PLANNING CONSULTATION RESPONSE

Application No	2025/0003
Proposal	Outline residential development for up to 21 units considering access and layout (Amended Plans and Description)
Address	Land adjacent 61 Shaw Lane, Carlton, Barnsley, S71 3HG
Date of Consultation Reply	10/09/2026
Consultee	Claire Wilson, Planning Ecologist

Drawing Title:
SITE PLAN

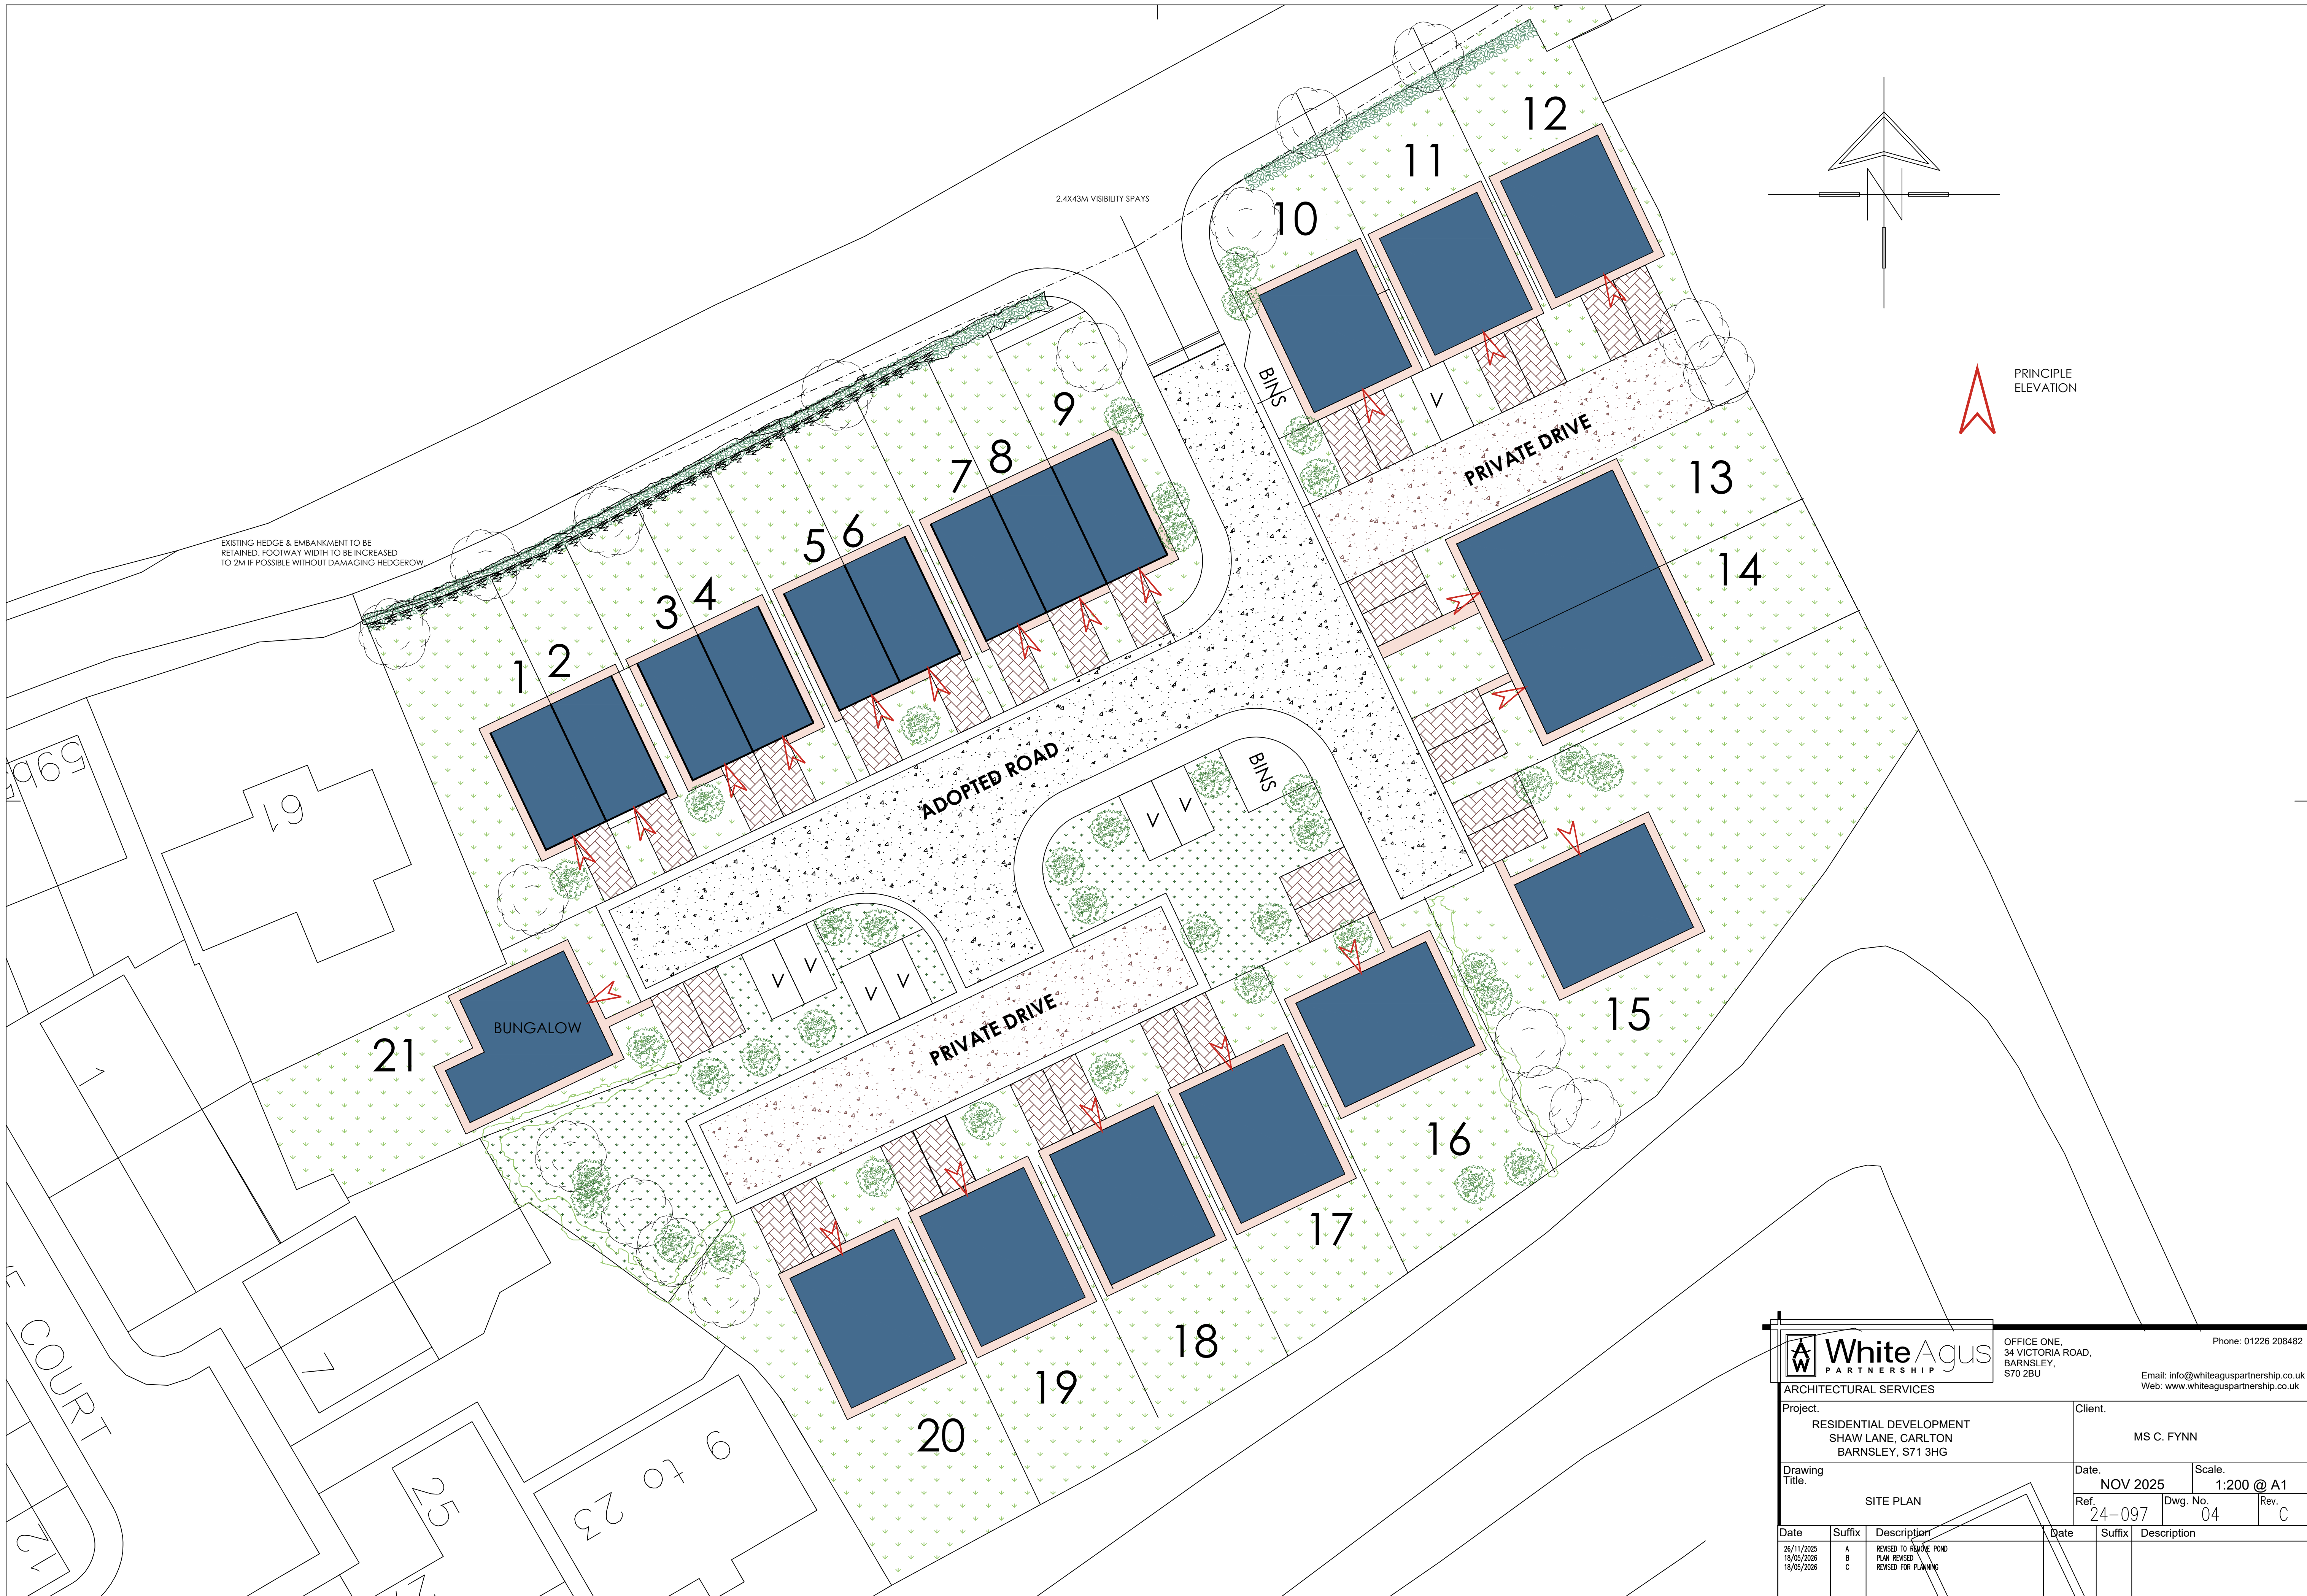
The post development BNG plan and metric indicates that other neutral grassland, a significant habitat type is proposed on site. Following a review of the site plan, I note that these areas are very small in size and located adjacent to car parking spaces, bin stores and pavements and would therefore be susceptible to trampling from residents. In addition, tree planting is also proposed within the areas of grassland. As such, I do not consider the creation of other neutral grassland in such small areas where there will be high levels of footfall to be realistic or achievable. To ensure a species rich grassland, management would only be undertaken twice per year to ensure a diverse sward, and this is unlikely on such small areas within a residential site. Modified grassland would be a more suitable habitat type for the site. However, as this is an outline application, this issue can be dealt with at the reserve matters application.
